From: Richard Goodall [REDACTED]
Sent: 24 August 2021 14:47
To: Simon Davis <Simon.Davis@arun.gov.uk>
Subject: Re: P/117/21/PL Sefter Farm

I am your case officer. I have had an initial look at the application and have a small query.

client BARFOOTS OF BOTLEY LTD			
project SEFTER EAST Proposed New Packhouse & Car Park Relocation			
title Location Plan			
date July 2021	scale @ A3 1:2500	drawn GBC	chkd GBC
project no. 2102	drawing no. 001	rev 02

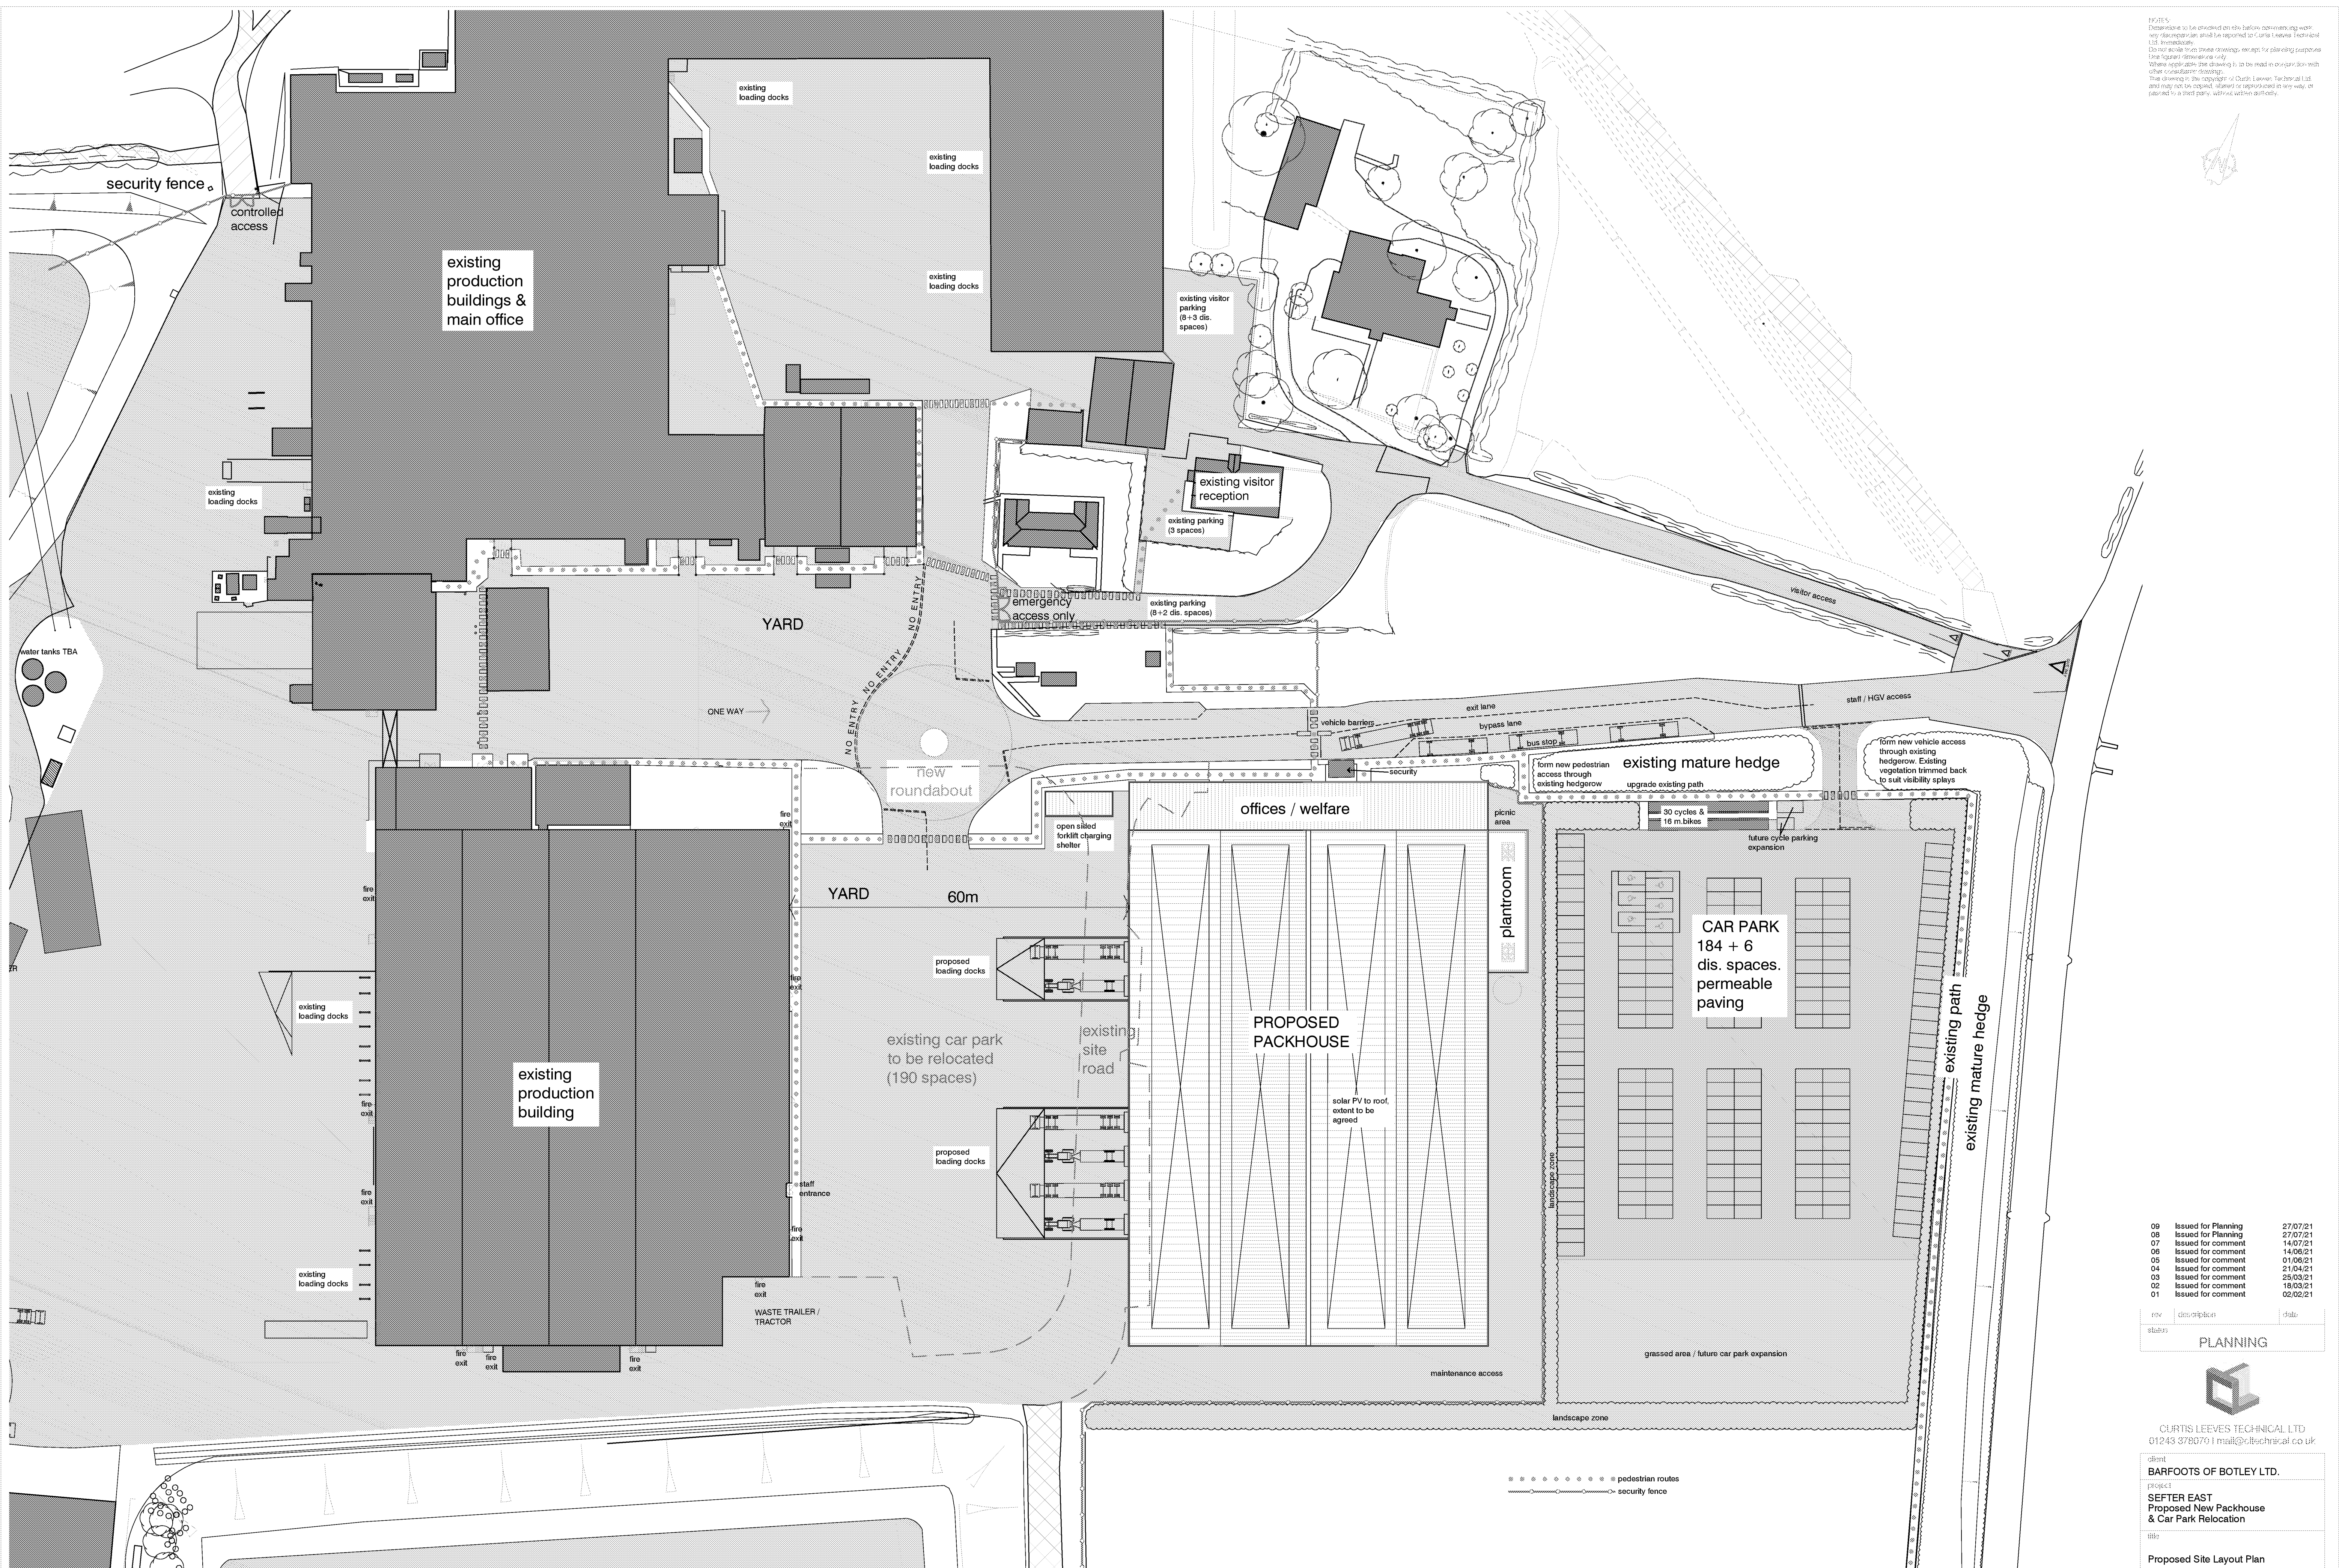
I note that you say in your planning statement that *The proposed building will be located on the existing staff parking area and clearly this will need to be relocated. A new parking area is therefore proposed on land between the proposed new building and Pagham Road immediately to the south of the existing site access.*

I understand this but the proposed site plan suggests that the packhouse will not actually be on the existing car park, touching/affecting it yes but actually sited east of it so this is a little misleading. It would also help if the proposed site plan was annotated to say "new service yard area on existing staff car park" (or similar) as opposed to "existing car park to be relocated (190 spaces)". My worry is that local people will compare the existing & proposed plans and think that there will be two car parks, one relocated and one new (as I did – before I then read the planning statement which local persons may not do).

Many thanks for your early assessment. I have requested a revised drawing which will hopefully address any ambiguity. I thought it was clear but obviously everyone in the project team is very close to it and therefore we don't have the benefit of an independent third party view.
